**Consultation Response from KC,
Lead Local Flood Authority**

2025/93066 land off, Lockwood Road and Albert Street, Lockwood, Huddersfield, HD1 3QW

Change of use of disused land to form car valeting facility (sui generis use) with welfare and storage unit.

Date Responded: 31st December 2025

Project No. 2025 Enquiry 70  
Project Title proposed entrance and side 1 elevations and front aerial view 2

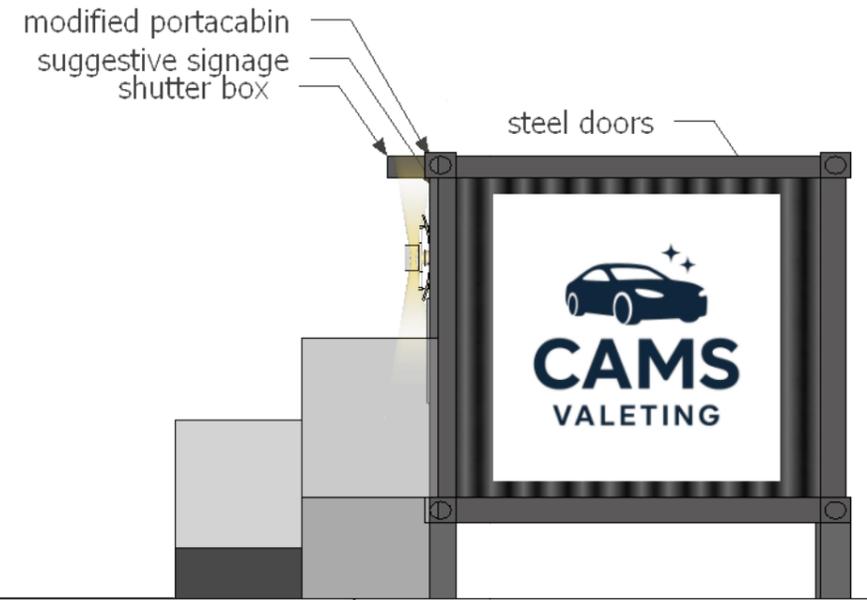
However, a sequential approach could be adopted. No formal flood risk assessment has been submitted, just a flood risk map with no commentary, assessment or proposed action. As part of the site is shown as flood zone 2 we would expect buildings to be positioned in this area, not flood zone 3. We would also expect an assessment on flood levels, including climate change to ensure optimum location and finished floor levels of the welfare unit.

Project No. 2025 Enquiry 70	Project Title proposed site and floor plan	Scale 1:200 @A3 size	Date 31/10/2025
Drawn By	Reviewed By MC		
Drawn No. 101	Reviewed Title		Revision A

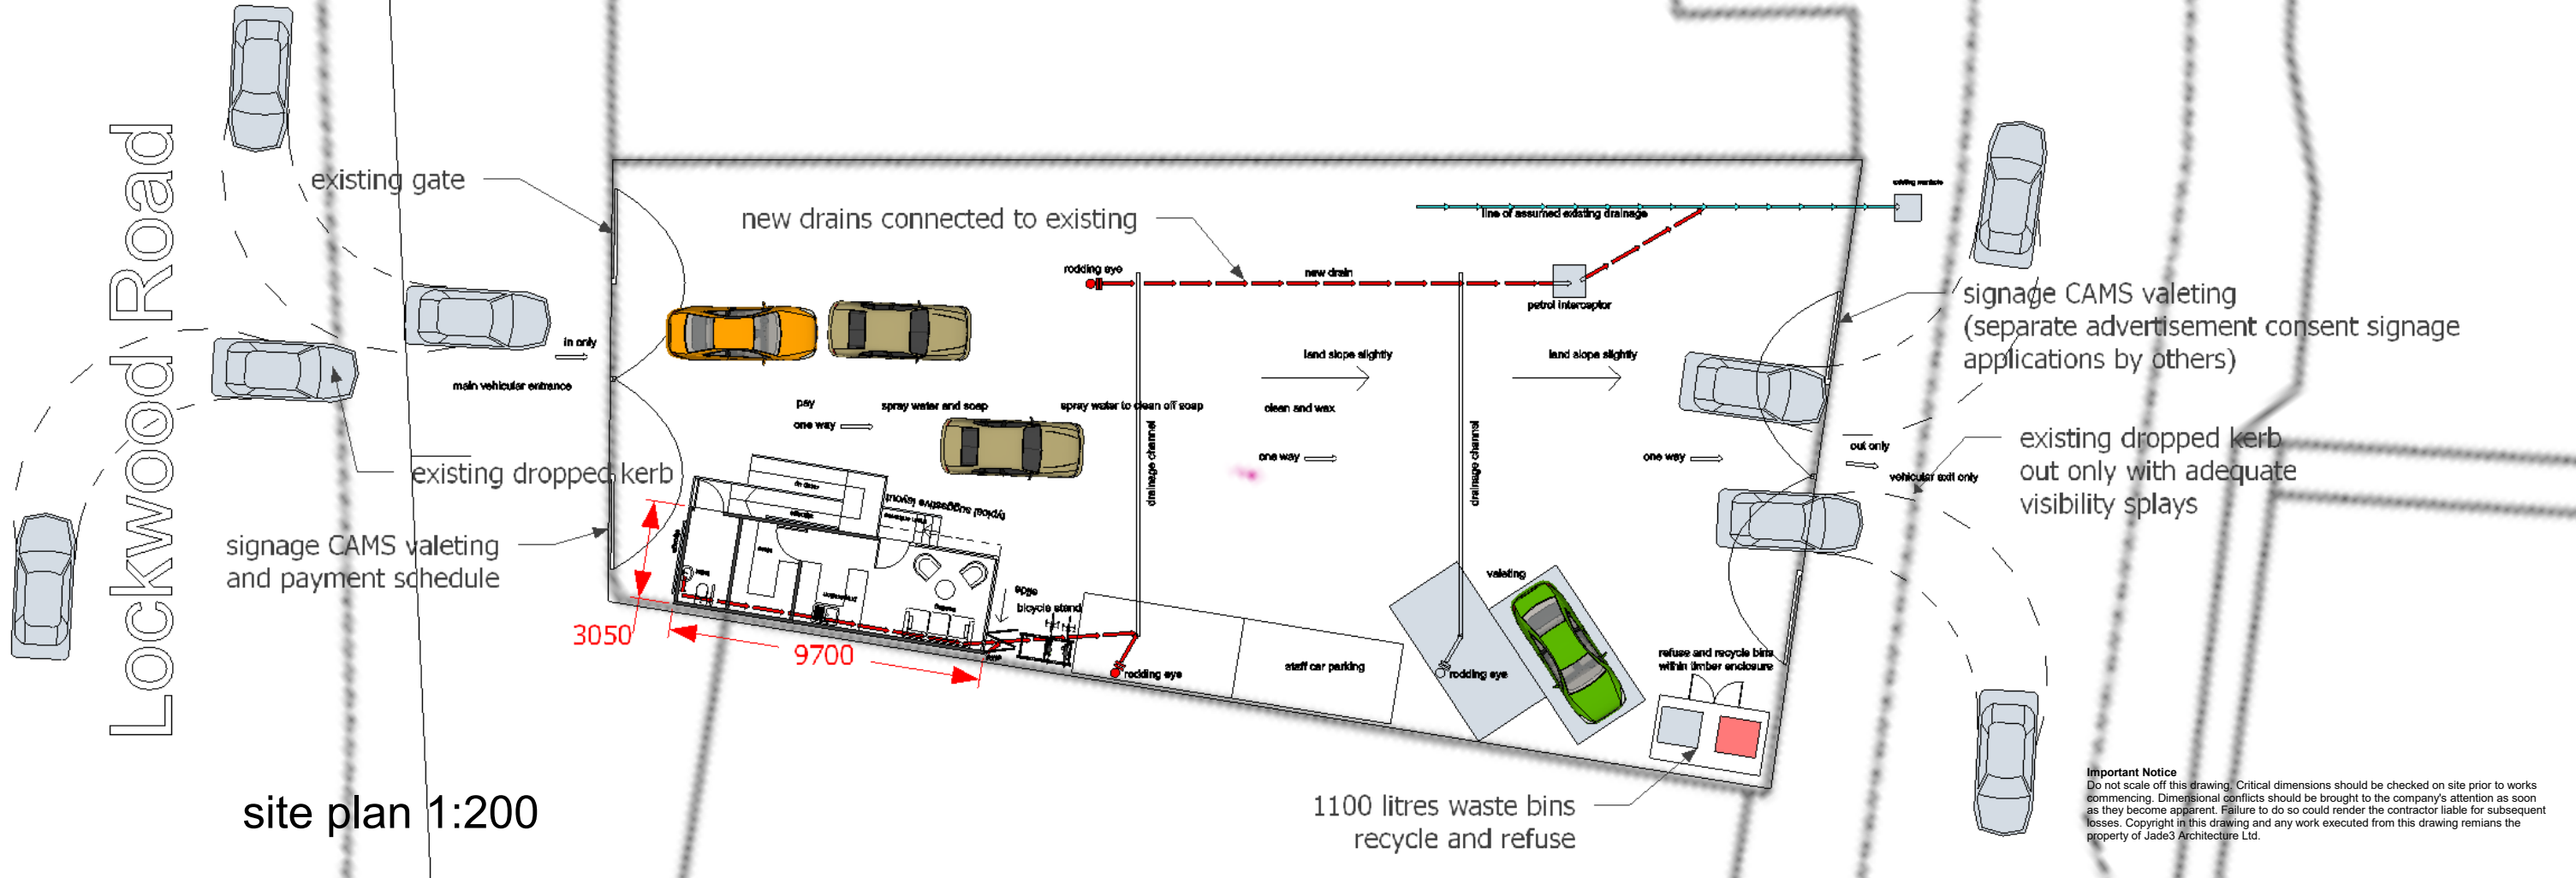
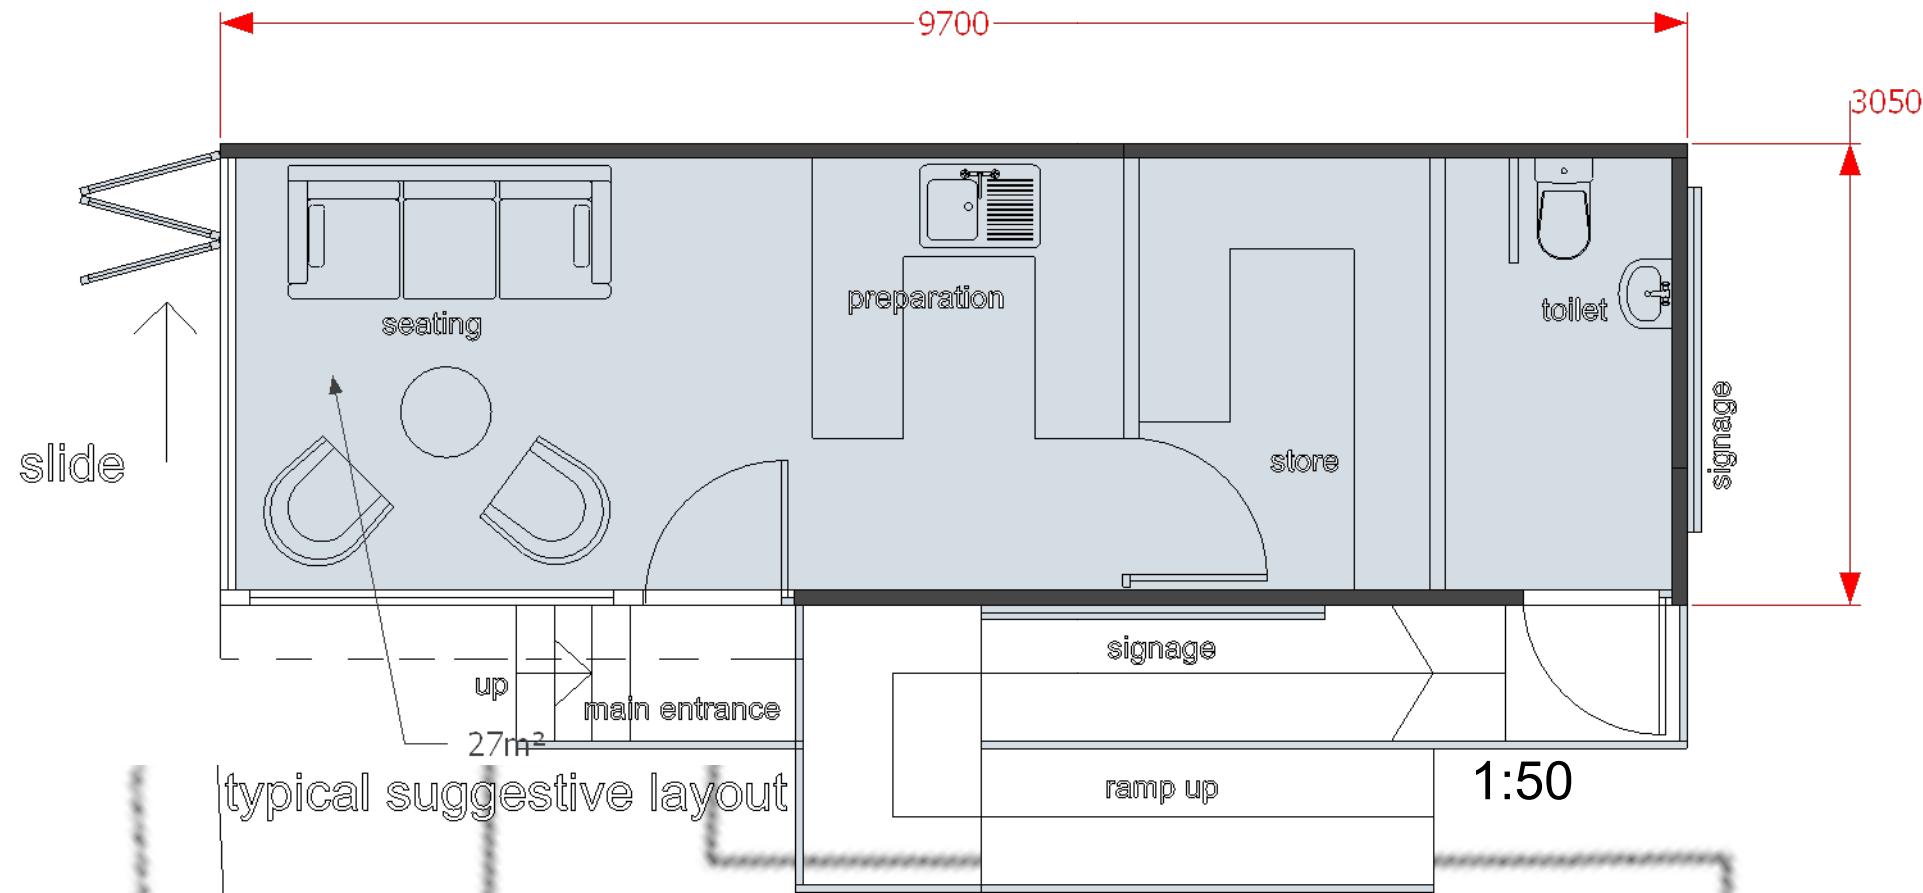
A **critical sewer**, a 525mm combined public sewer is shown as built over. This cannot be handled under part H of the building regulations due to its size. Yorkshire Water may wish to stipulate a suitable stand off distance from this building. Although a diversion could be sort, this may not be practical given the potential expense and considering the building needs to be relocated for flood risk as well as avoiding building over. An assessment of the depth of the sewer would dictate stand off distance.

Yorkshire Water provide the following guide where it can be seen that at least 3.5m if not greater, depending on its depth will be required from the centre line of the sewer.
